## Engineers Comments Regarding Surface Water Drainage

<b>Application Reference:</b>	Y/32/25/PL	<b>Reviewer Reference:</b>	ADC/EXT4
<b>Planning Officer:</b>	Simon Davis	<b>Date of Review:</b>	24/10/2025
<b>Site Name:</b>	Land West of Bilsham Road Yapton BN18 0LA		
<b>Application Description:</b>	Erection of 170 No. residential dwellings (30% affordable), parking spaces, internal site roads, public open space, children's play space, pumping station, surface water drainage features, landscaping and associated works. This application is a Departure from the Development Plan and is in CIL Zone 3 and is CIL Liable as new dwellings.		
<b>Assessment Number:</b>	2 of 2

Drawing Title  
**PROPOSED SURFACE WATER DRAINAGE LAYOUT, SHEET 7 OF 8**

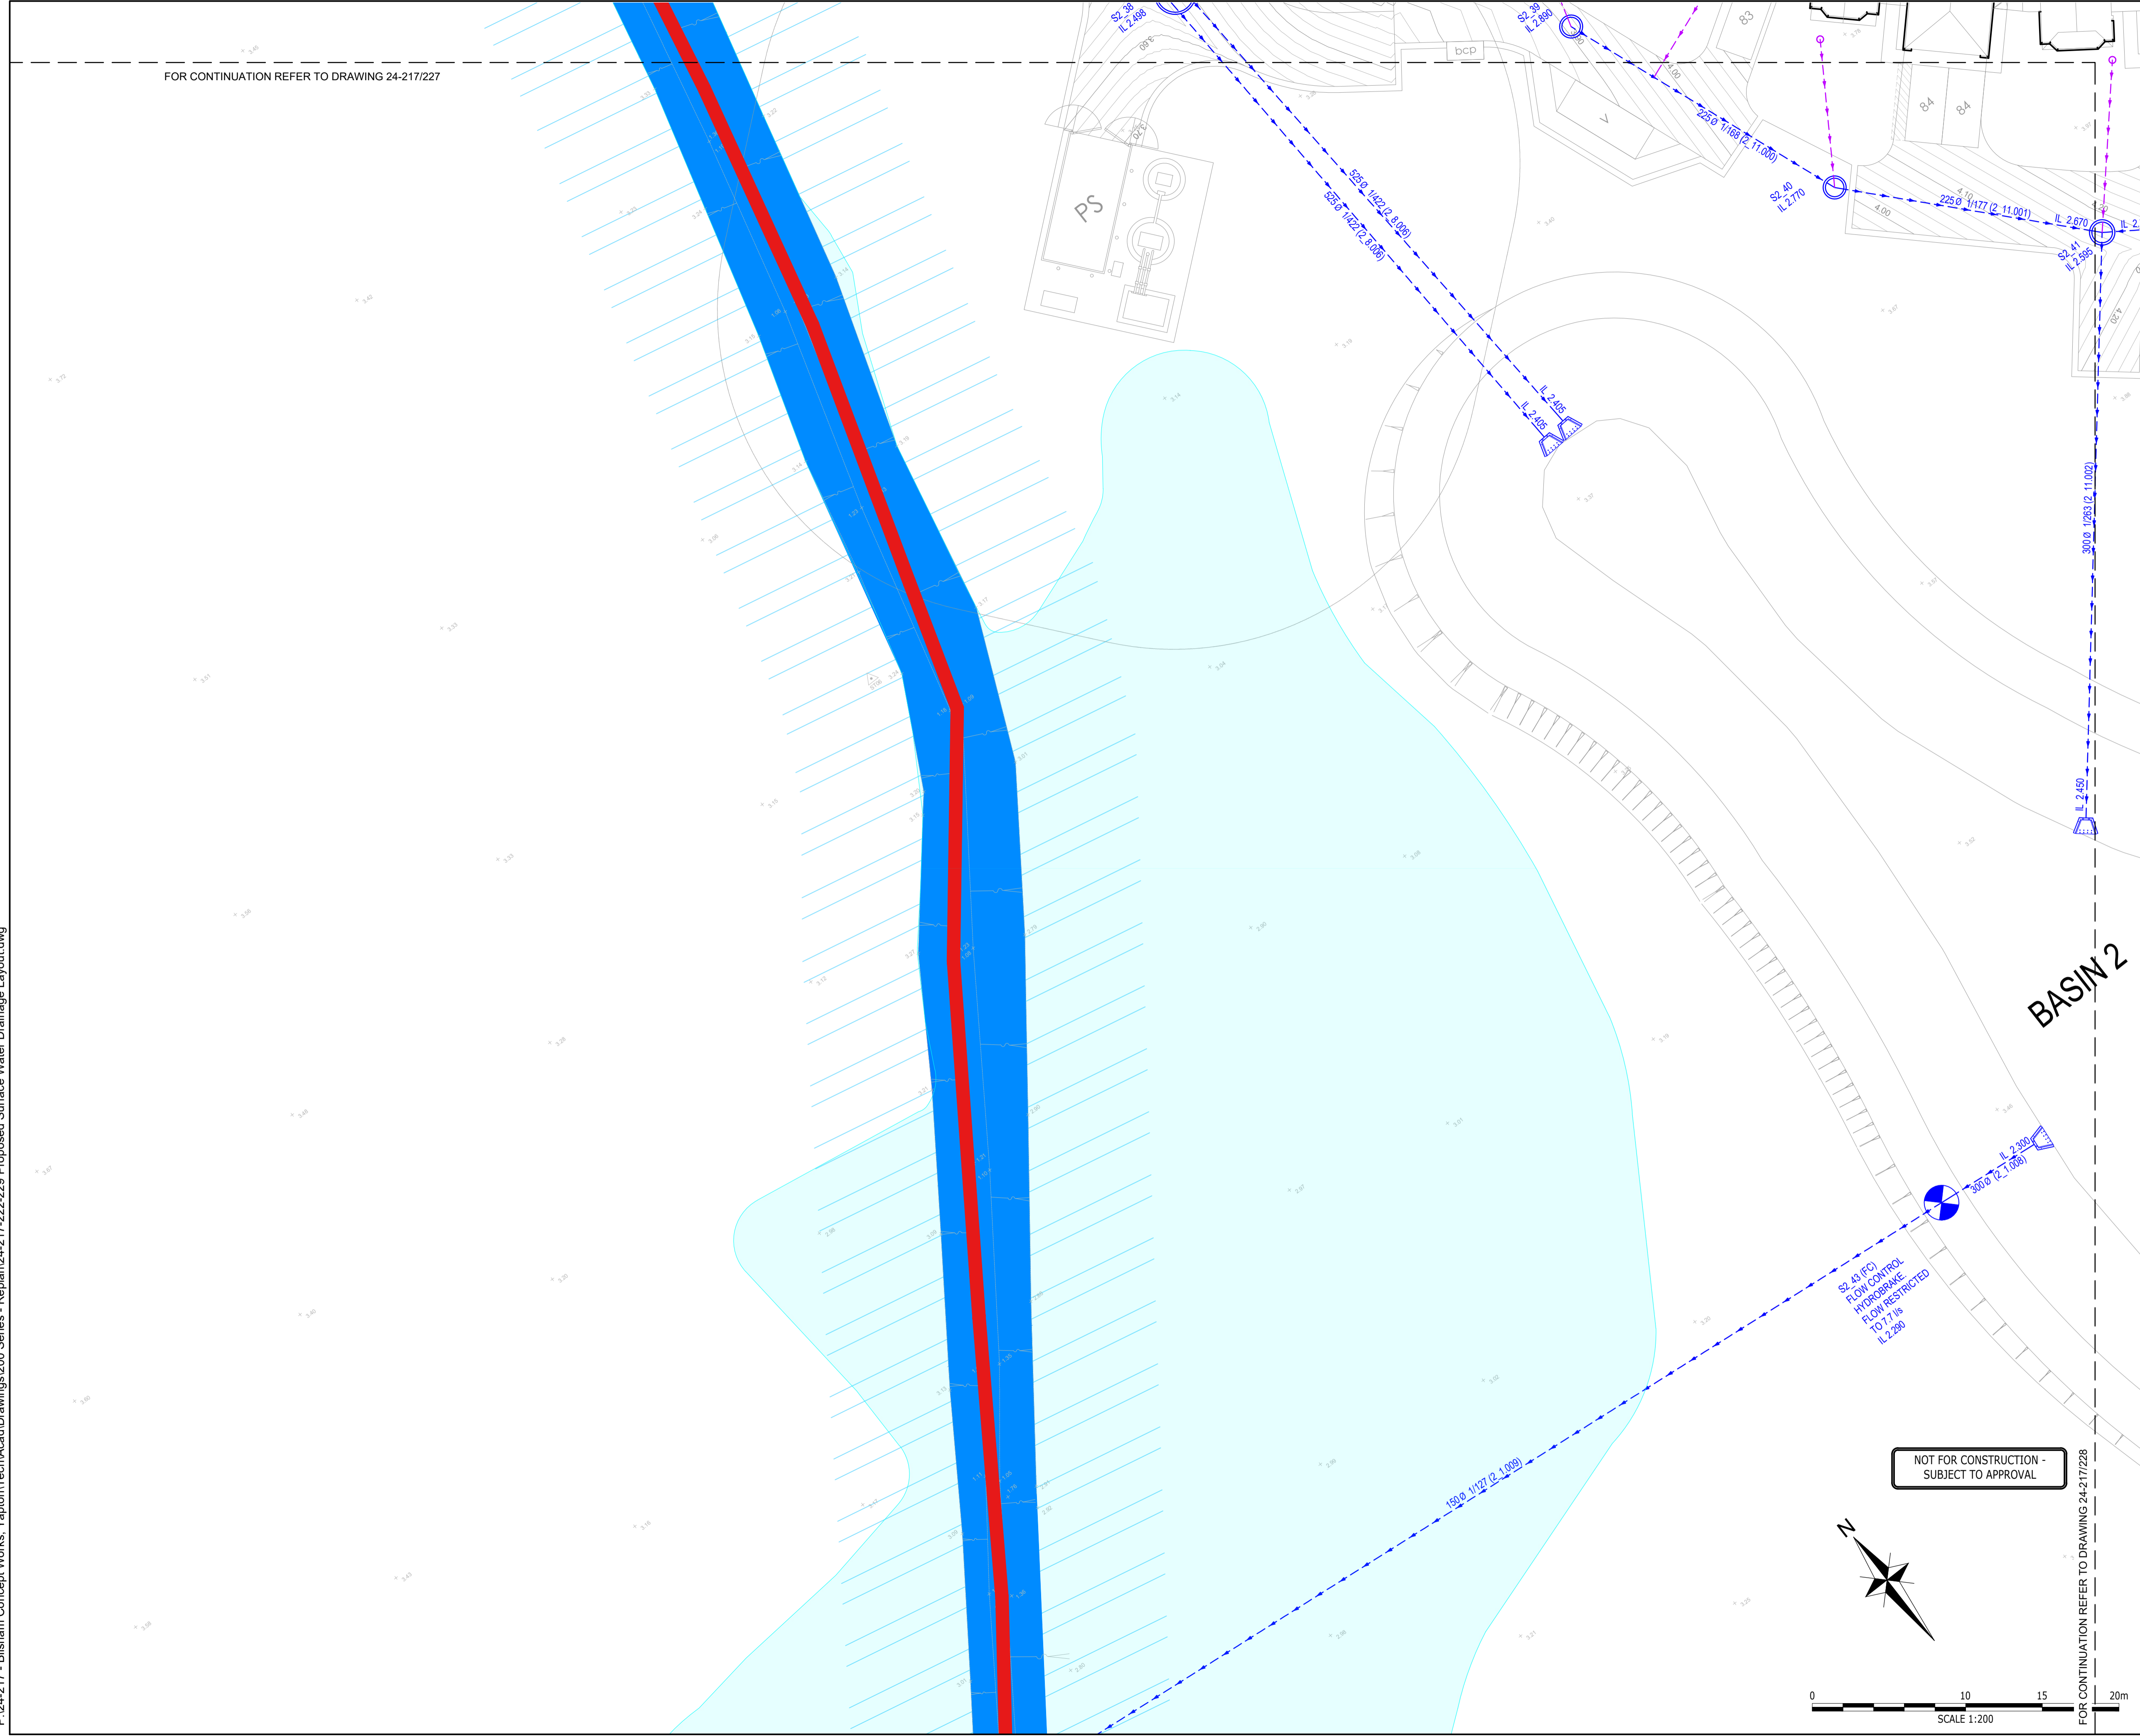
5.3. The depth of basin 1 is 2.320m the peak design water level is 1.715m and whilst still less than 2m, the planning officer and designer are expected to consider the health and safety risk of the depths of the basins, in terms of increased risk, or the implications on amenity if barrier fencing is required. It is noted that The SuDS Manual dissuades the use of physical barriers to water as they can prevent or obstruct visual observance of the water body, and the provision of help in an emergency.

7.1. The proposed attenuation basin 1 appears over 2m deep and will likely encounter groundwater. The ability of constructing and operating these basins whilst including adequate measures to counter the buoyancy effect of the high groundwater without impacting the current proposals is a concern. The concern is that there is a risk that the size and layout of the basins may need to change in plan area during the detailed design stage. This could result in an increase in plan area to account for reduced depth, impacting the layout and deliverable public open space area. Alternatively, the designer may increase the volume of below ground attenuation tanks thus reducing the water quality and biodiversity benefits these basins currently provide.
